BUILDING CODE OF AUSTRALIA REPORT

**Proposed Commercial Building,
Olympic Park Site 13, Homebush Bay**

Dated: **10 March 2008**

BCA ASSESSMENT REPORT
Proposed Commercial Office Development,
Olympic Park Site 13, Homebush Bay

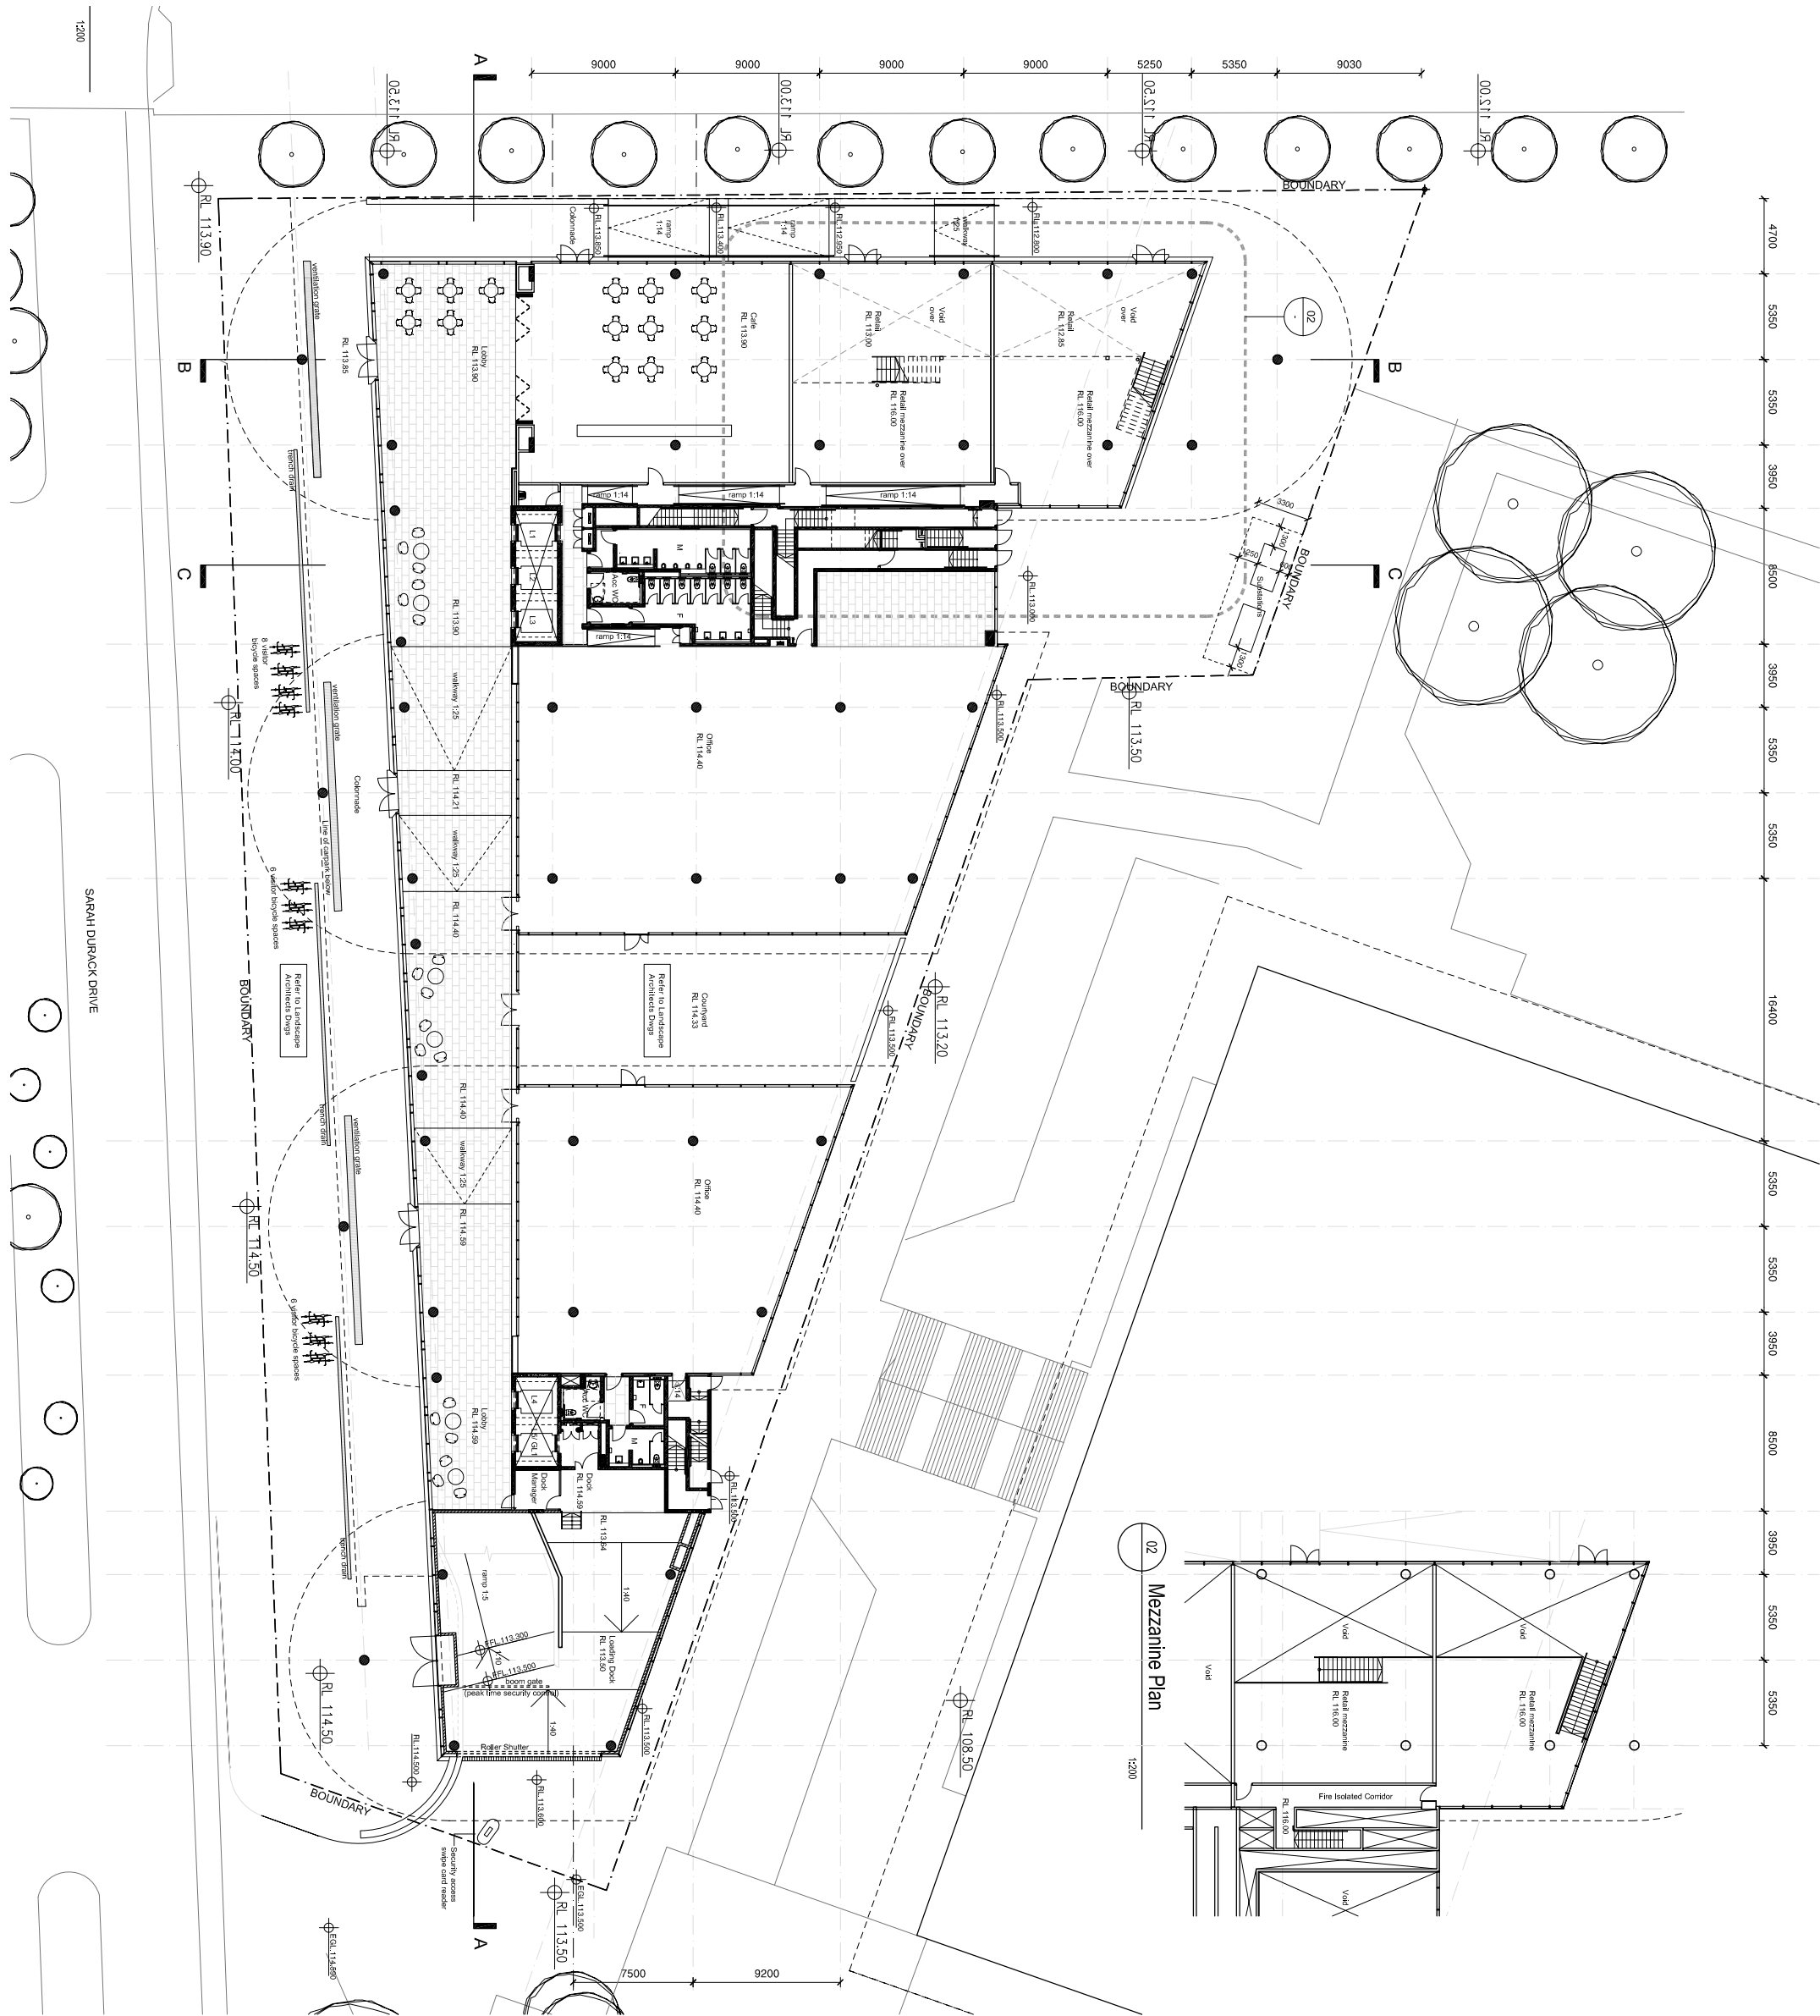
1. Distance of travel to an exit on the Ground Floor Level in Building A currently exceed the prescriptive 30m to a single exit (38m). Therefore this item will be required to be assessed under the performance requirements of the BCA pursuant to DP4 of the BCA.

- **Podium Level:** Please note on an open floor plate a maximum distance of travel to an exit was measured as 38m, within the largest commercial suite to a single exit. This item will be required to be addressed as part of the ongoing design development for the site, as the distance exceeds the prescriptive 30m to a single exit.

This item may be addressed via providing an additional exit within the largest Retail suite or via a performance based assessment by a suitably qualified fire engineer, in accordance with Performance item DP4 of the BCA.
